An Bord Pleanála
Strategic Housing Unit
64 Marlborough Street
Dublin 1
D01 V902

Date: 23 May 2022
Our ref: 3237/22/5
Your ref: ABP - 313361

Re: SHD planning application for the construction of a total of 415 No. residential units (252 No. houses, 135 No. apartments, and 28 No. duplex units); with 1 No. childcare facility and ancillary residential amenity facilities, a proposed Strategic Housing Development, on lands at Back Road & Kinsealy Lane, Kinsealy, Broomfield, Malahide, Co. Dublin.

Boundary Treatment | Southern Section | 1:1000

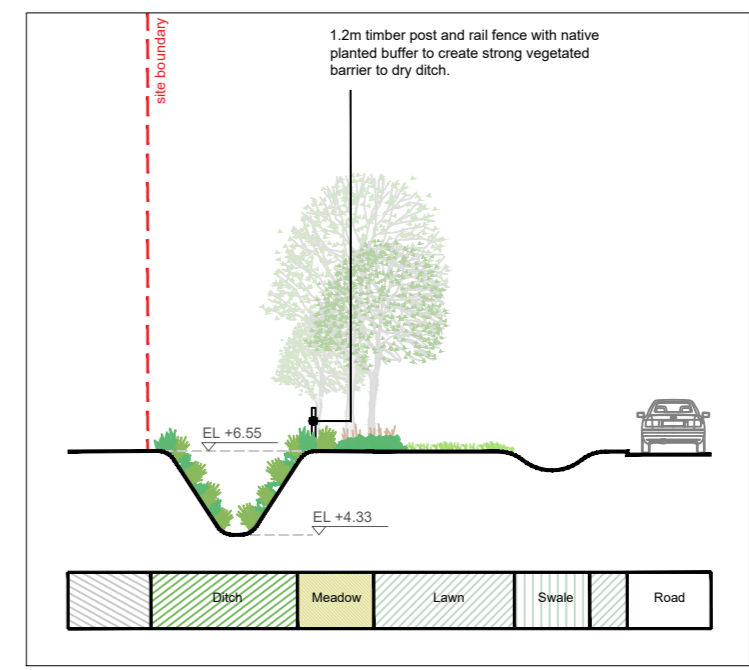
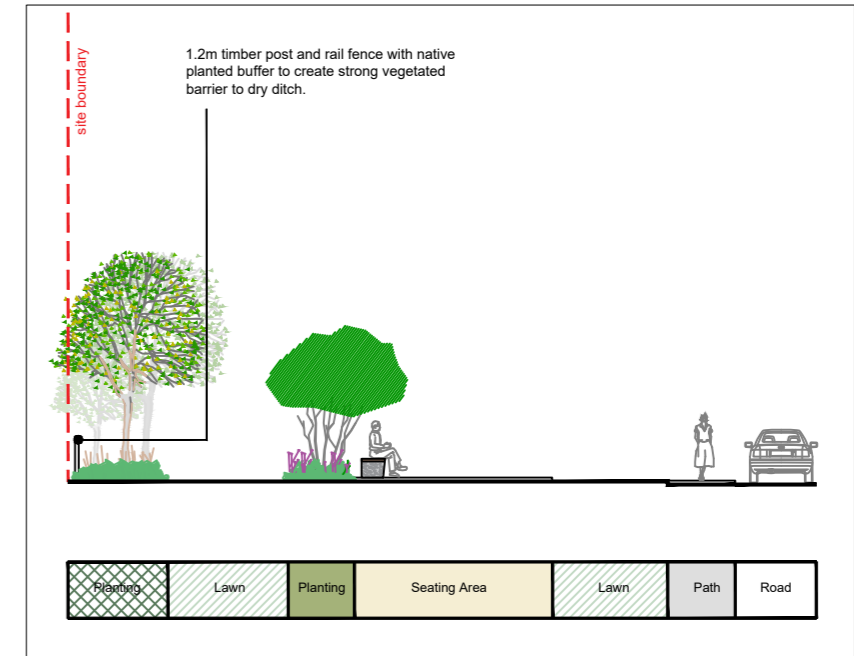
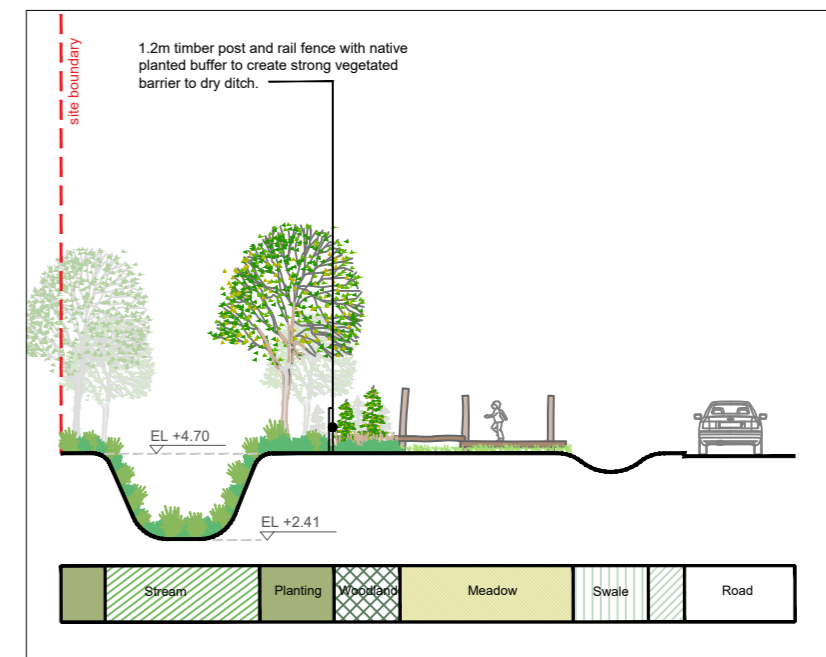
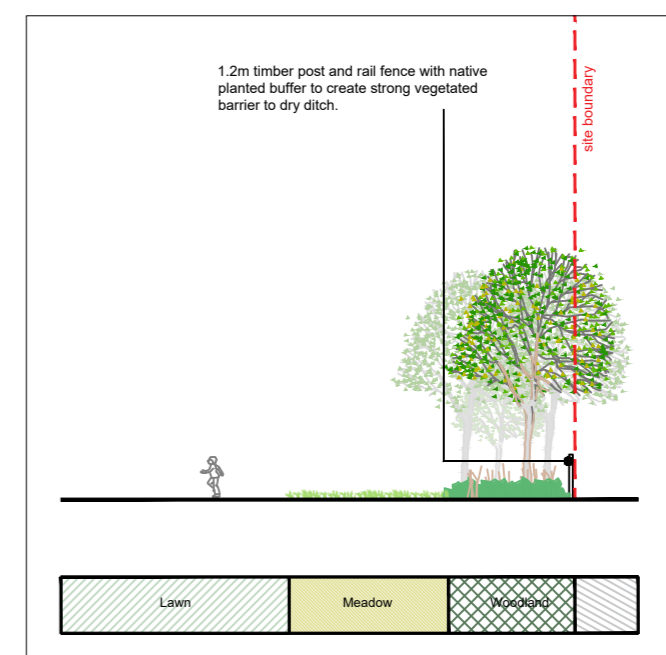
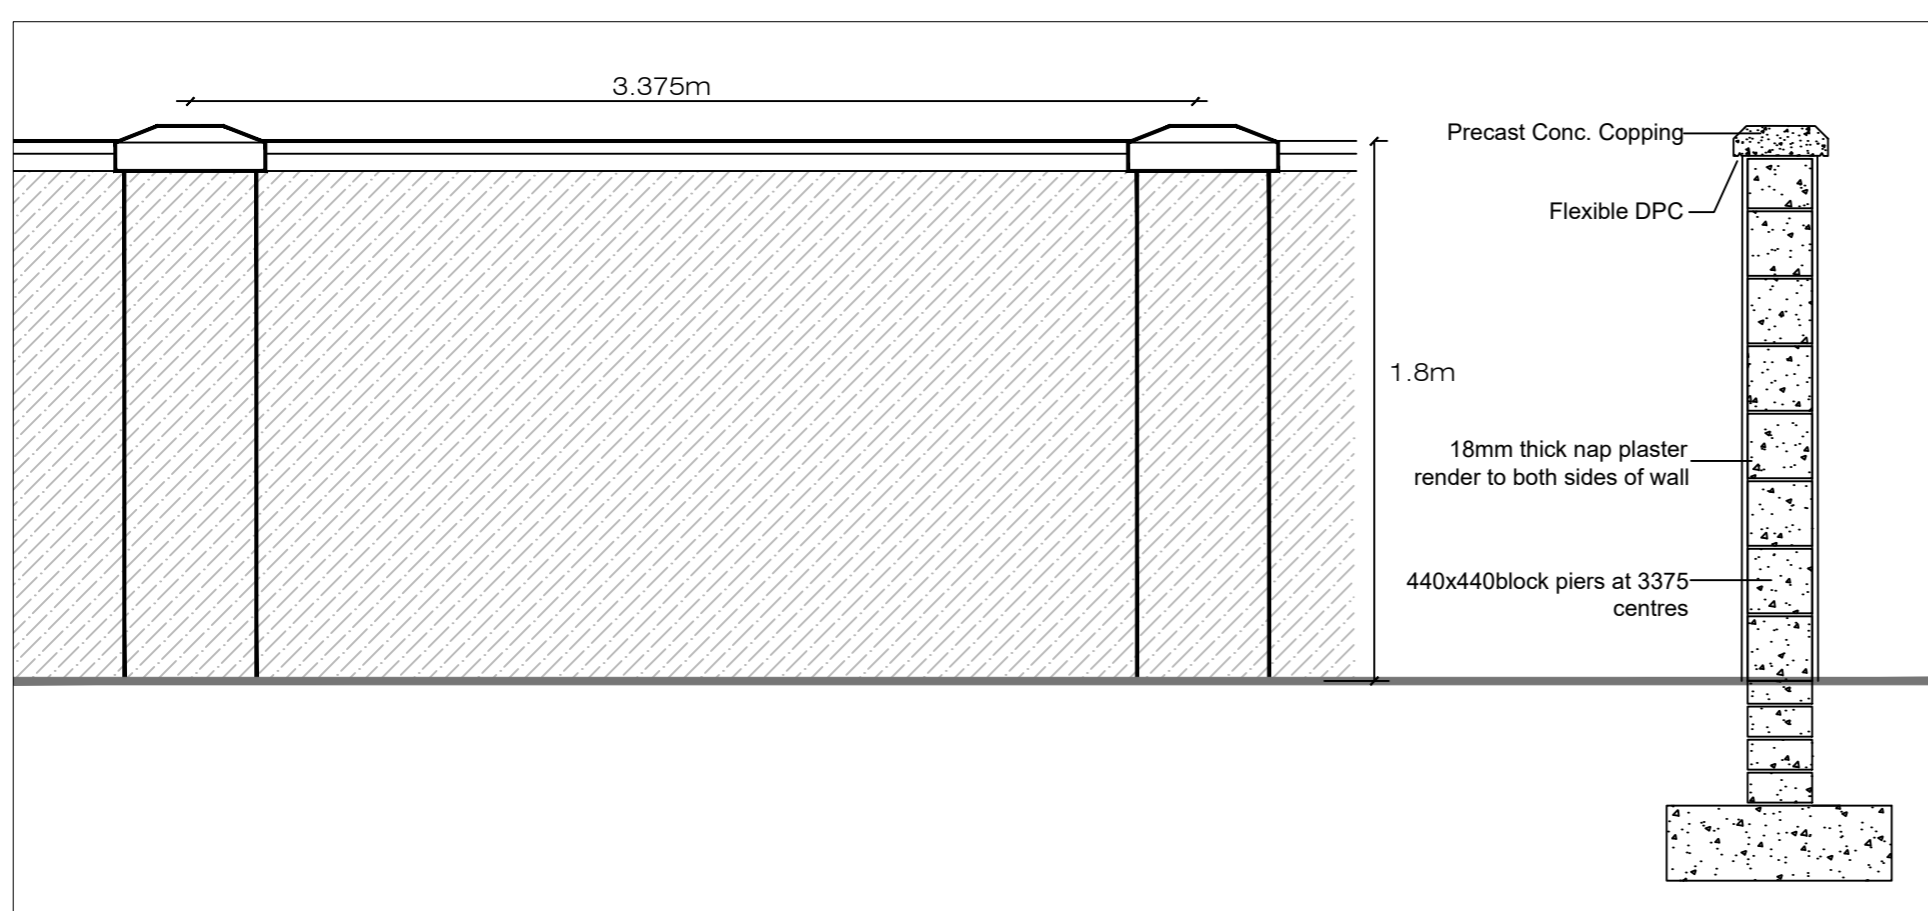
- 3) The site boundary shown on the plan drawings assumes that the property boundary to railway lands corresponds with OSi mapping. This approach is unreliable and does not take account of the historical drainage channels running parallel to the railway at the crest of the cutting which fall within the original land take for the railway corridor. It is therefore probable that the proposed development encroaches onto CIÉ/Iarnród Éireann lands. It is noted that the drawings provided by the applicant under the heading of Architectural Drawings do not specify a dimension between any new boundary wall and the track, or alternatively GPS coordinates for the line

of the wall that would allow for comparison with the Railway's records for the boundary line along this section. The Applicant should engage with Iarnród Éireann and provide detailed cross sections with a view to agreeing the line of the proposed boundary treatment.

- 8) In keeping with a residential development of this scale and density a 2.4m minimum high appropriately designed, solid block/concrete boundary wall treatment, should be erected by the applicant on the applicants' side of the boundary to the Railway. The maintenance of this boundary treatment rests with the Applicant and Successor-in-Title. It is noted that the planning documentation refers to provision of a new boundary welded mesh fence at the track interface, this however is not in keeping with the access and security issues associated with a development of this scale and type. As mentioned previously, the exact location and details of the boundary treatment are to be identified on site in co-operation with this office.
